# City of Albuquerque Stormwater Construction Site Inspection Report

General Information					
ESC File No.	H11E075		Project Name:	Playa del Sur	
NPDES Id. No.	NMR1006DO		Location:	5720 Miami Rd NW	
1/21/2025	Owner		Contractor		
Operator	Butterfly Holdings, LLC				
Contact name & title	Jarrod Likar				
e-mail	jarrodl@aswinc.com				
Contact Phone #	505-596-9037				
COA Inspector	Chancellor English		Start/End Time:	1pm	
Construction Phase:	Grading				
Type of Inspection:	Regular	Storm Event	Post Storm Event >0.25"	311/Complaint	Follow Up
Weather at time of inspection?	Clear		Temperature:	~ 30	
Estimated date of last storm 0.25" or greater			11/7/2024

DRAWN BY  
AS  
DATE  
05/08/24  
DRAWING  
2023076-SWPPP  
SHEET #  
SW-3  
JOB #  
2023024

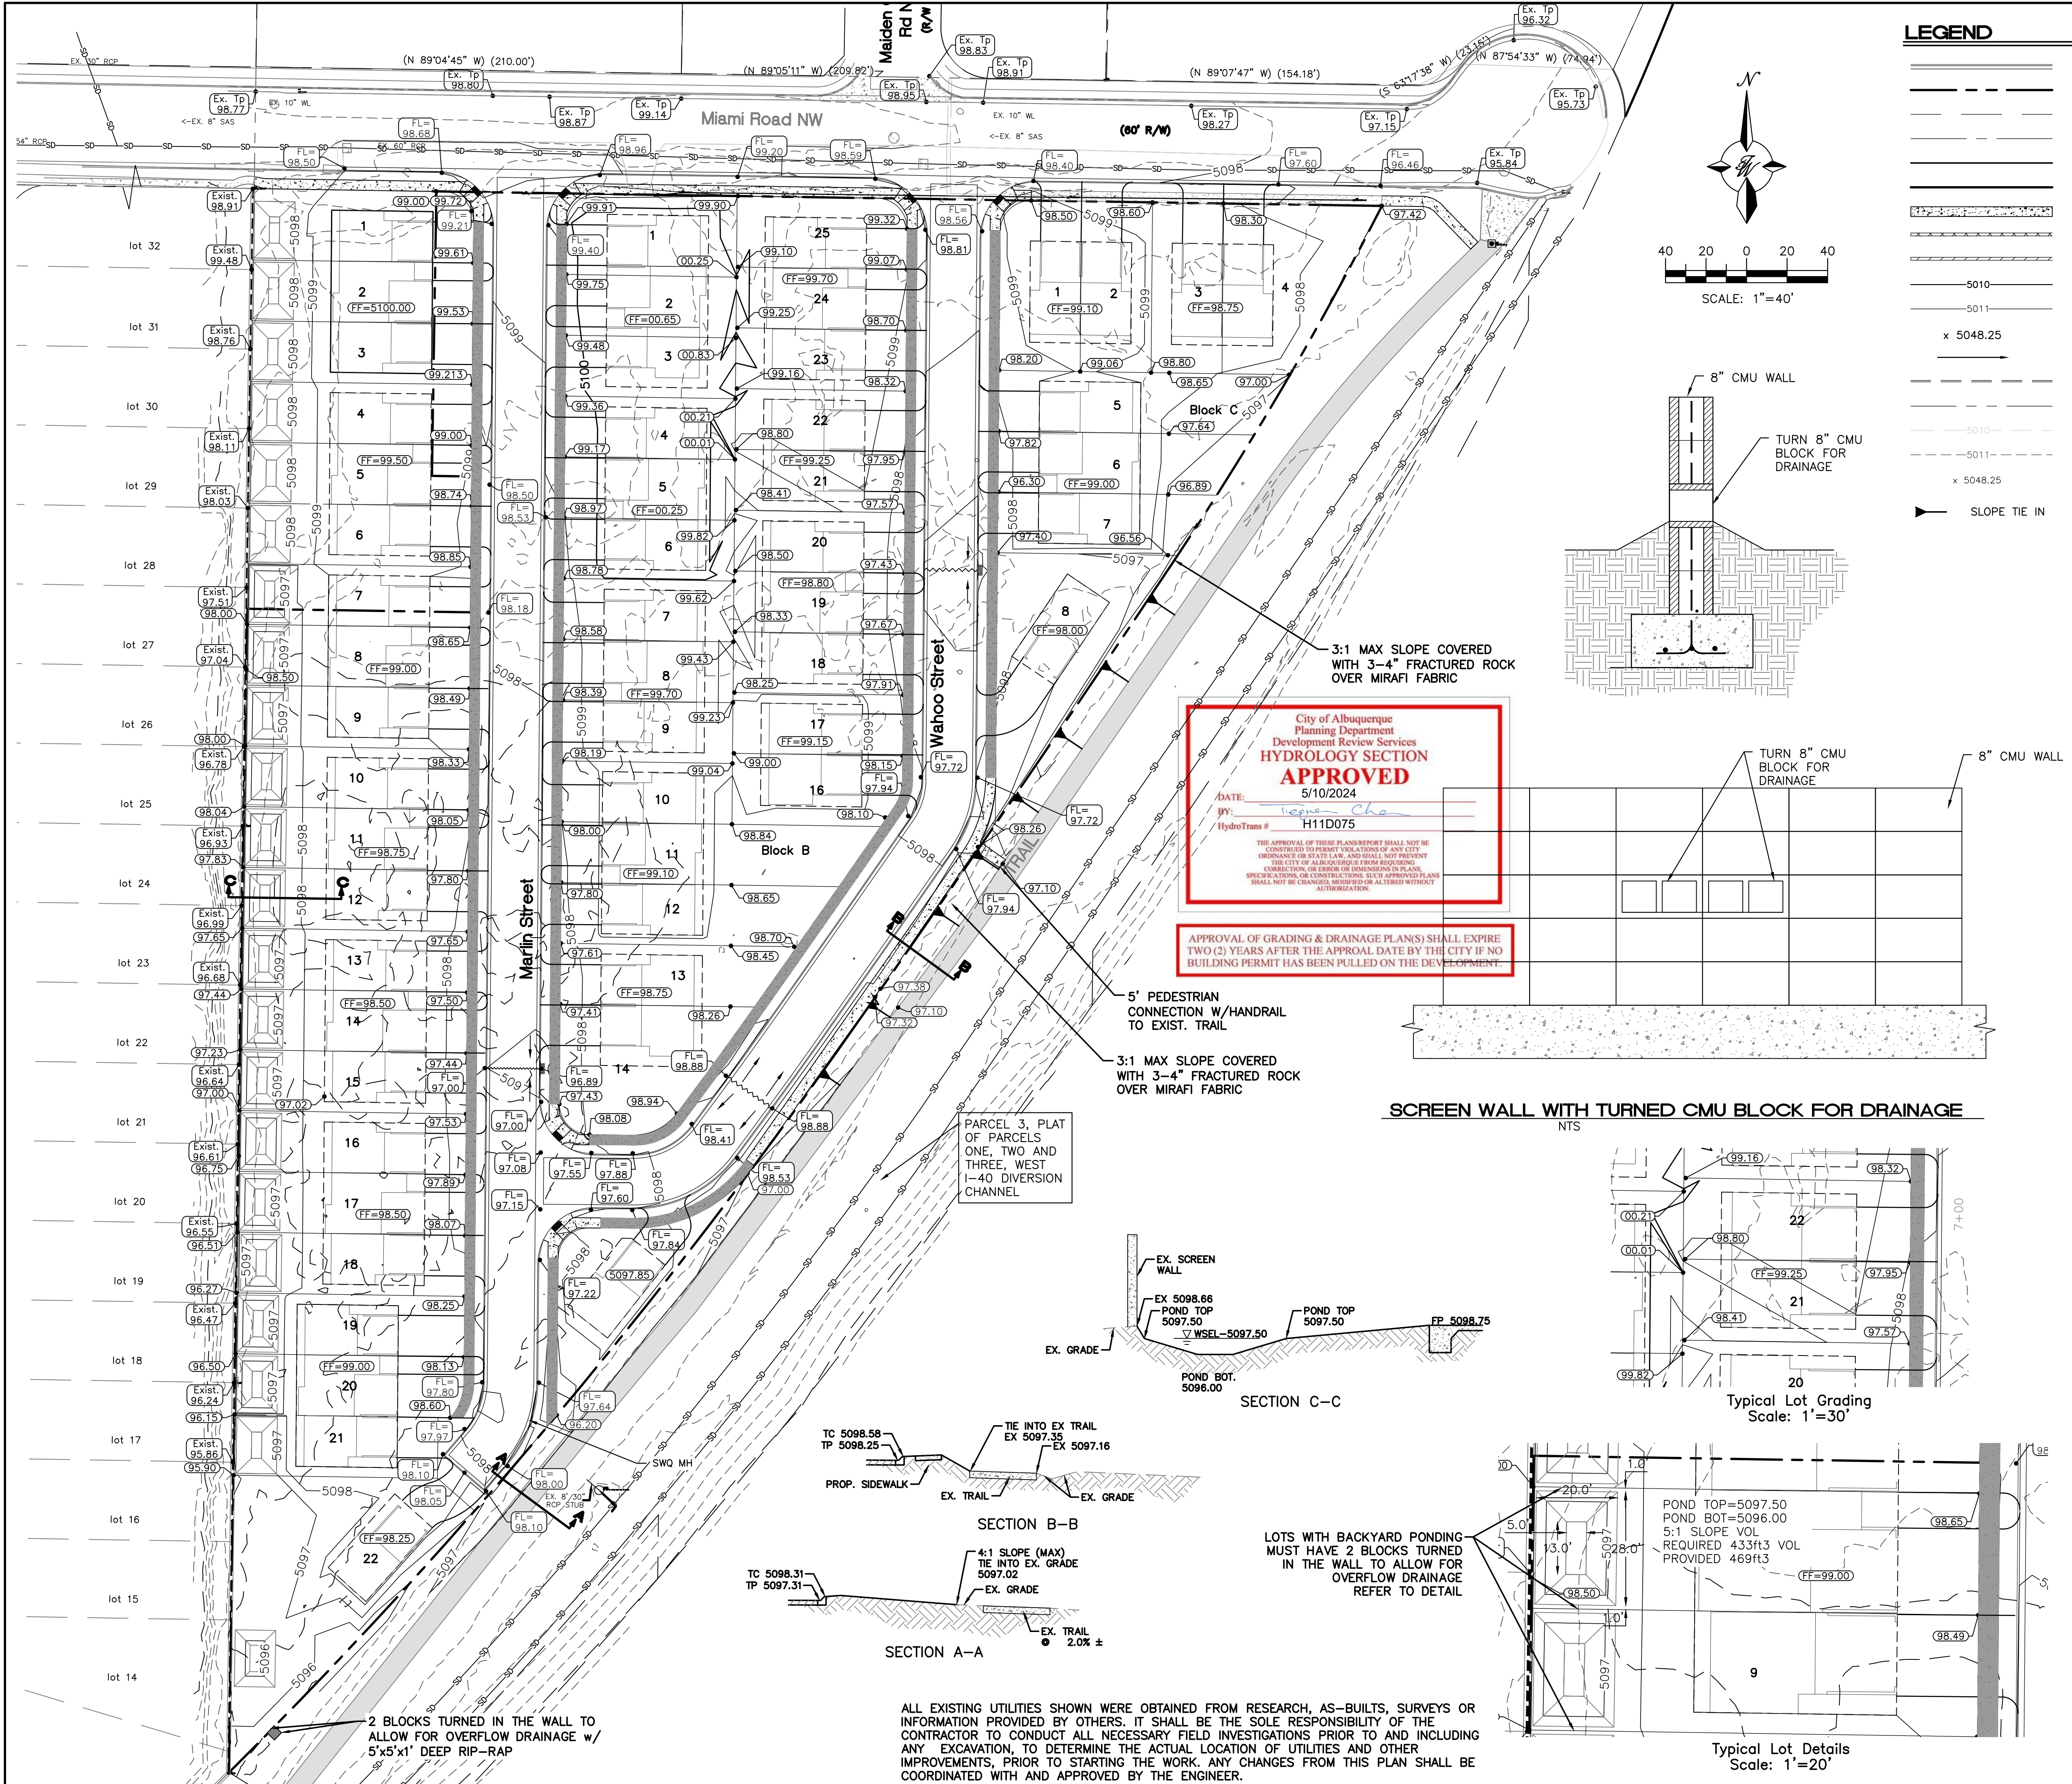
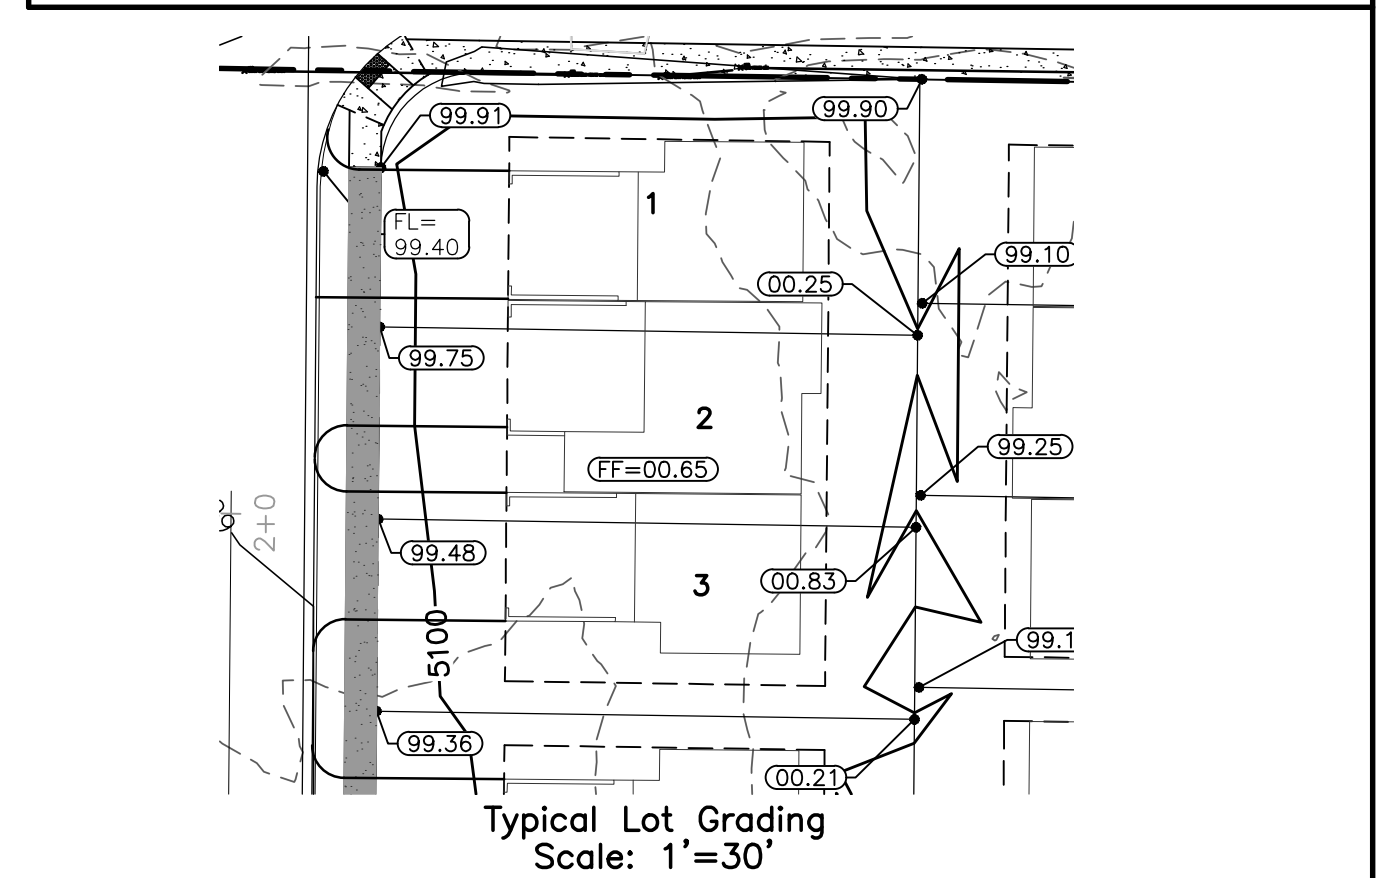
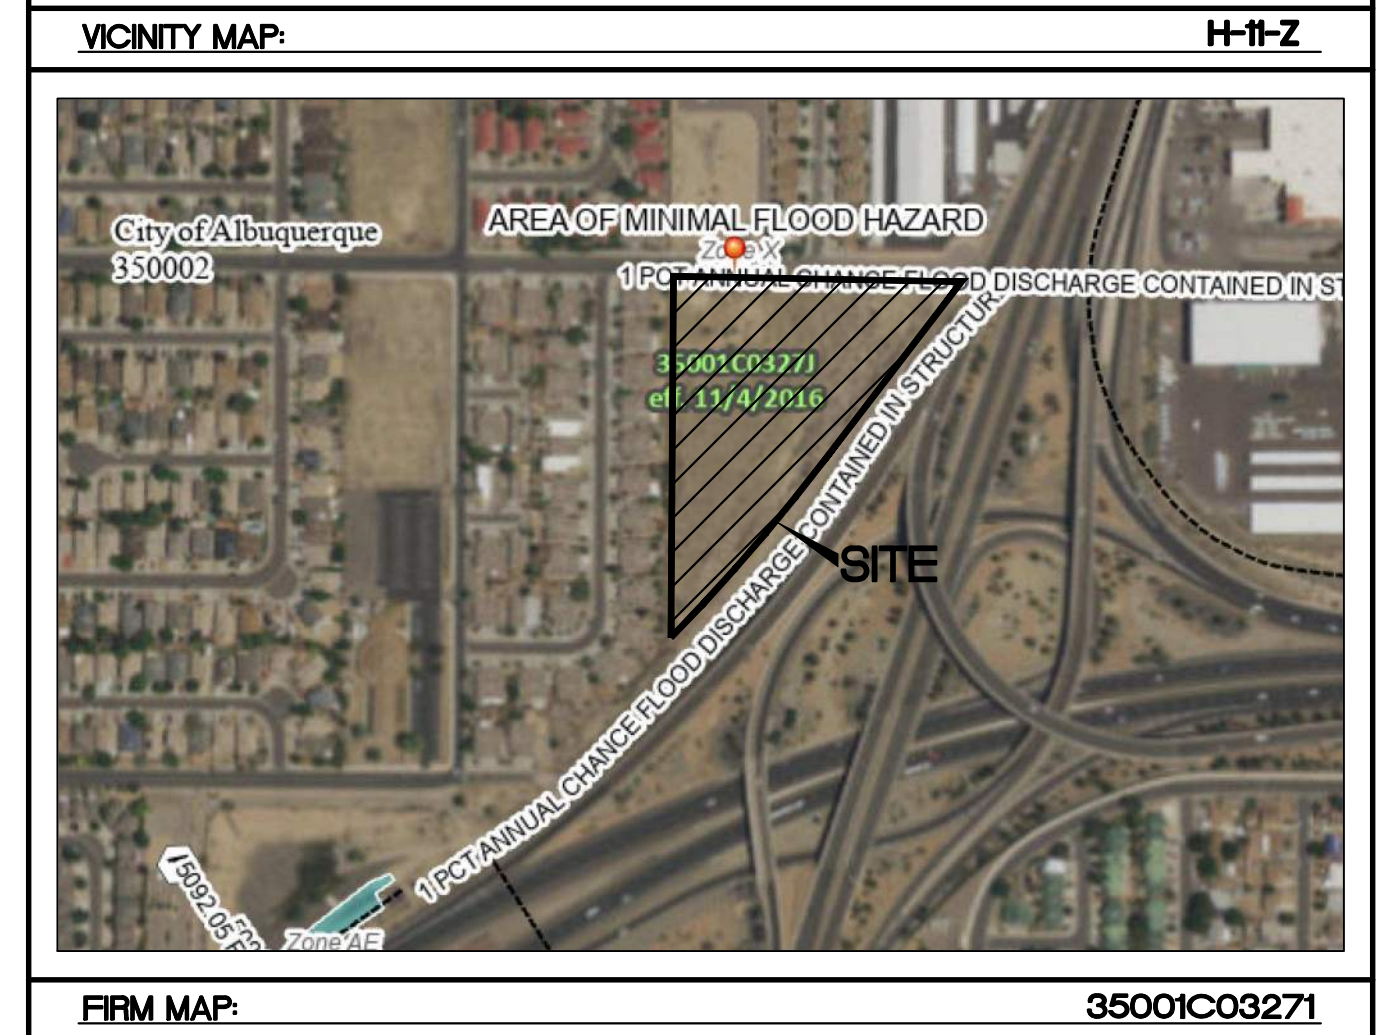
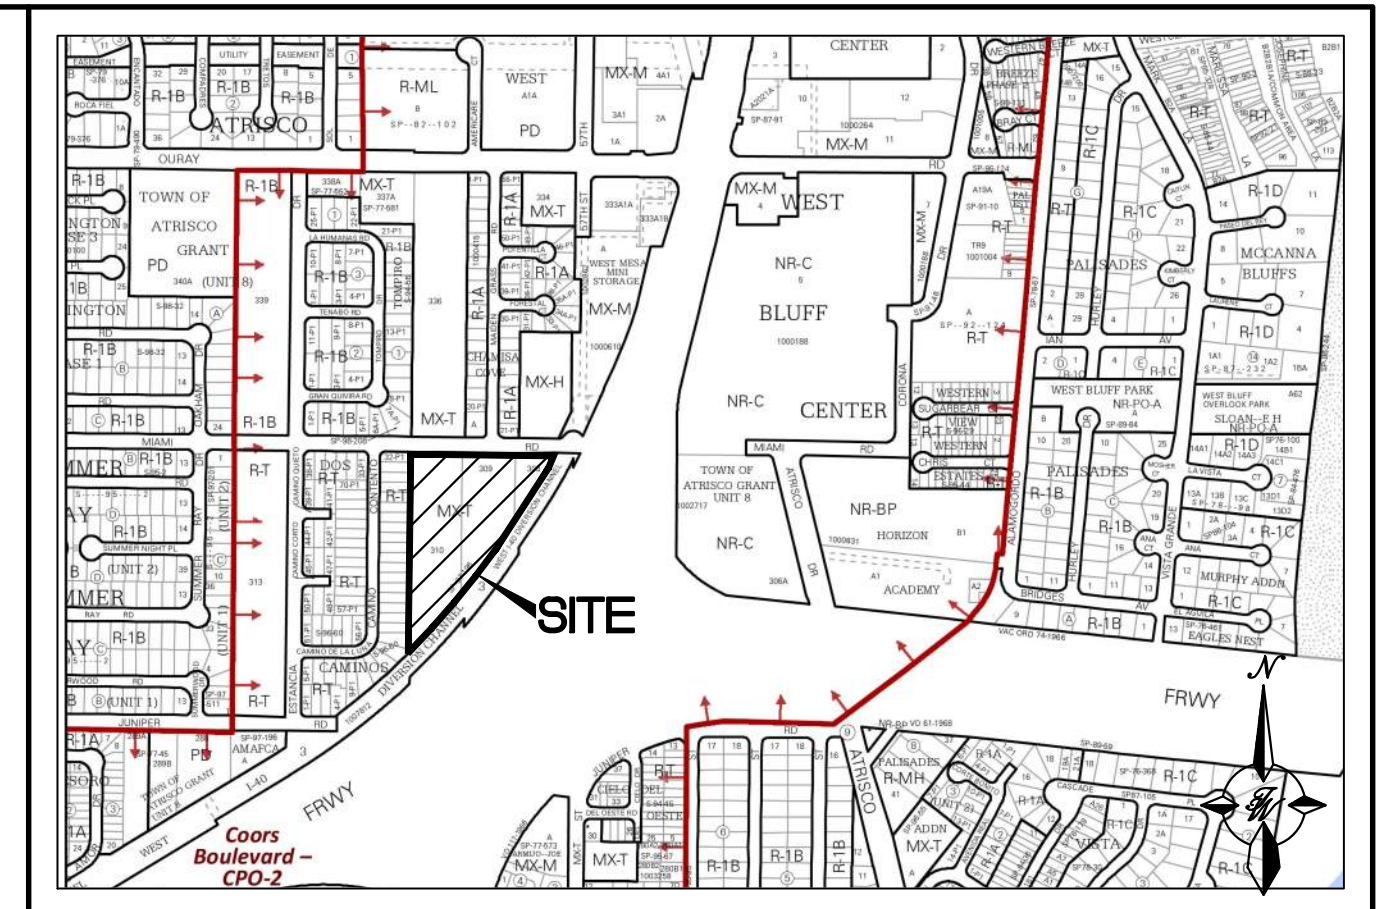
Item Number	Deficiency/ Corrective Action				
1	SWPPP - The SWPPP map does not reflect the current conditions of BMPs, materials storage, and sediment basins in violation of CGP Part 7.4.1. The self-inspection reports are not current in violation of CGP Part 4.7.3. Required mitigation: You must modify your SWPPP, including the site map(s), within seven days whenever you make changes to your construction plans, stormwater controls, or other activities at your site that are no longer accurately reflected in your SWPPP per CGP Part 7.4.1.a. You must keep a copy of all inspection reports at the site or at an easily accessible location, so that it can be made immediately available at the time of an on-site inspection per CGP Part 4.7.3.

Notes:	
The construction exit is full of sediment and needs maintenance/clean-out.	
Please send the most current self-inspection report.
